Our ref: DOC20/77598

Senders ref: MP06_0168-Mod-7

Subject: Snapper Mine Mod 7 (MP06_0168-Mod-7)) - Response to submissions

ATTACHMENT A BCD comments on Snapper Mine North Mod 7 (MP06_0168-Mod-7) - Response to Submissions

TRONOX
S N A P P E R M I N E
Location of Groundwater
Monitoring Sites

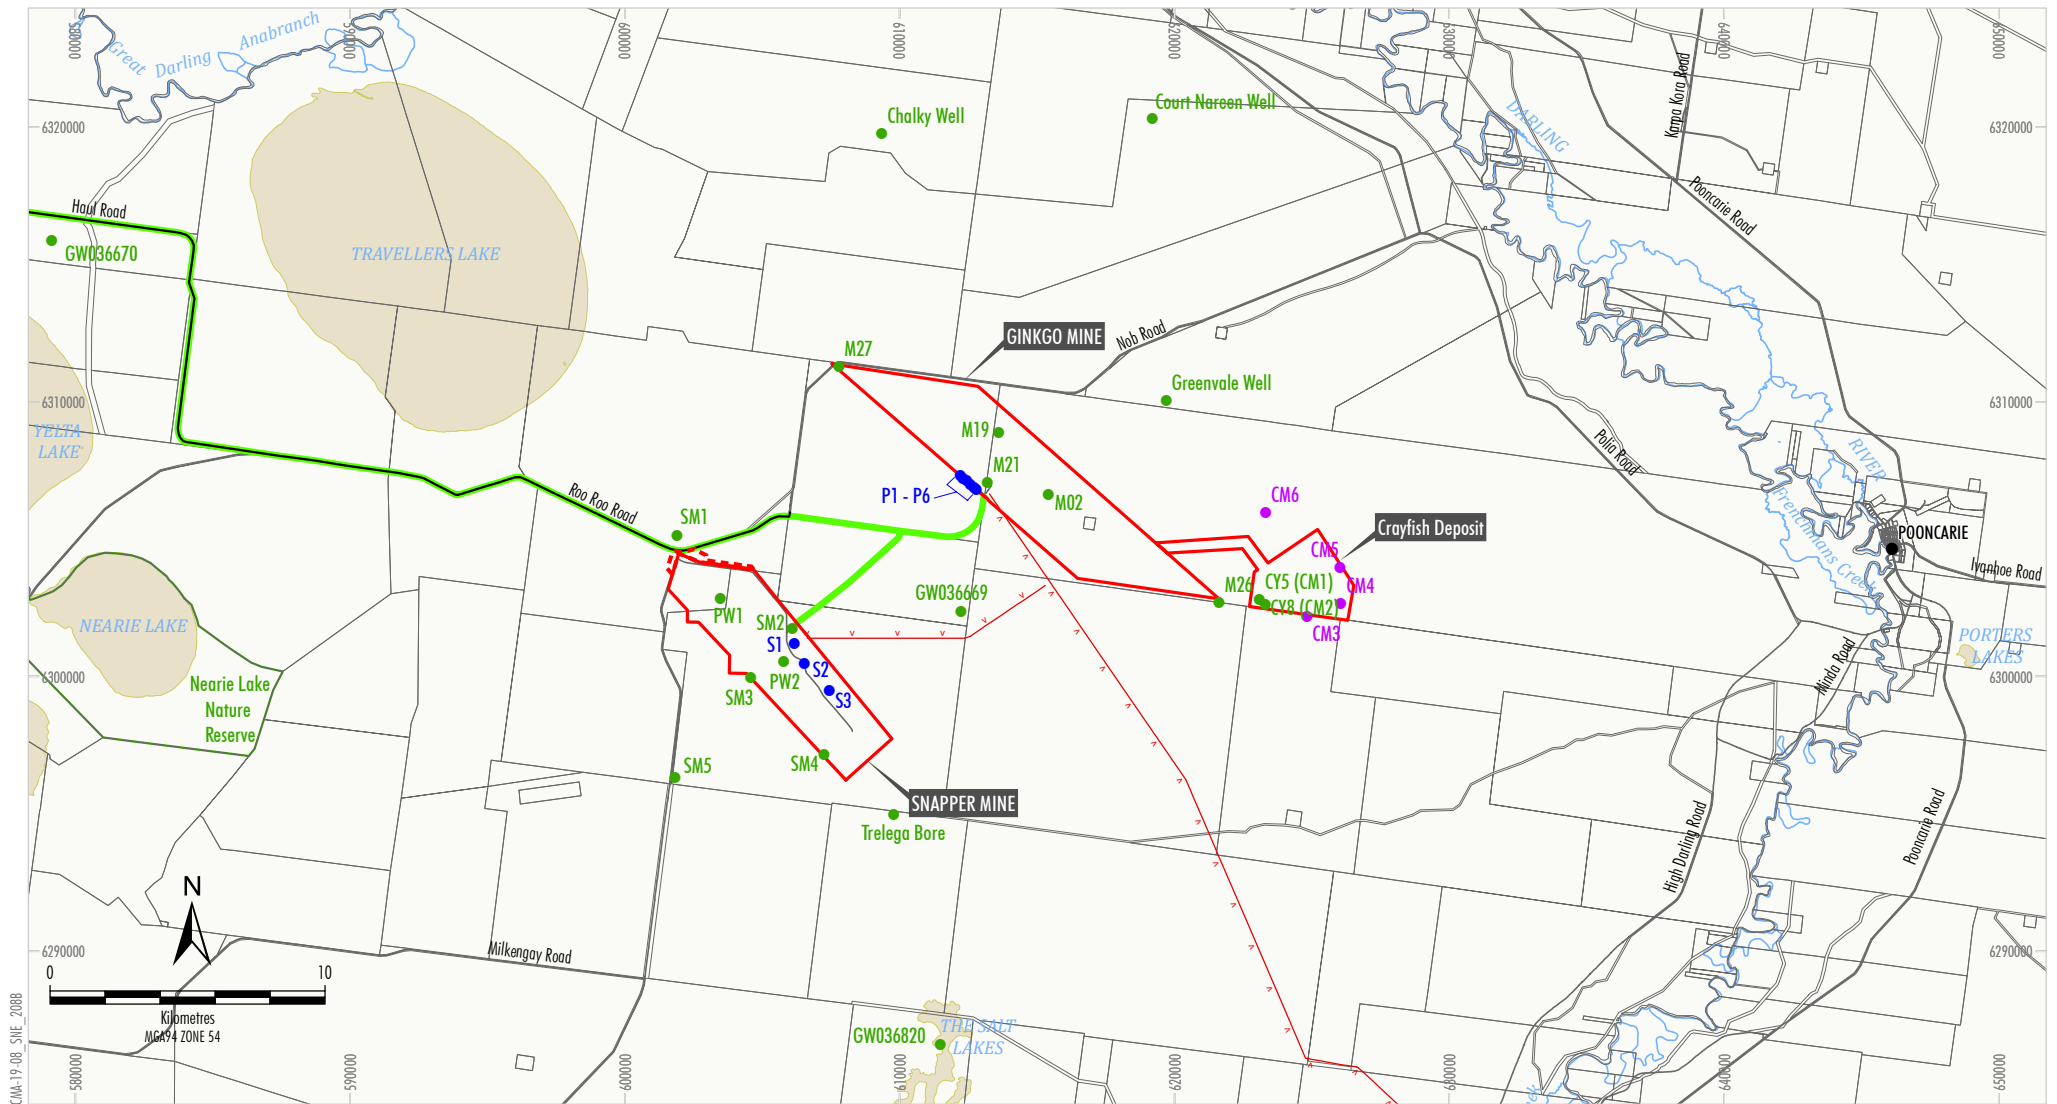
BCD Issue 3	Monitoring bore GW036669 is located between the Snapper and Ginkgo mines (see Figure 3 in EIS Hydrogeology Report). Ginkgo Mine commenced in late 2005, Snapper Mine commenced towards the end of 2009. The Department's examination of WaterNSW monitoring data indicates that GW036669, which had been stable since 1990 (AHD=-34-36m), now shows a decline (~1m post 2010). Importantly there are greater fluctuations in two of the bore holes (holes 2 & 3) post-2010, whereas levels in bore hole 1 remained relatively constant.
	The variability in bore GW036669 holes 2 & 3 post 2010 may potentially be indicative of an impact of the Snapper mine on levels in those bore holes The Department should have access to raw monitoring data to enable an independent assessment of the groundwater and surface water impacts, if required
Recommend	Raw monitoring data to be supplied to the Department on request be a condition of consent
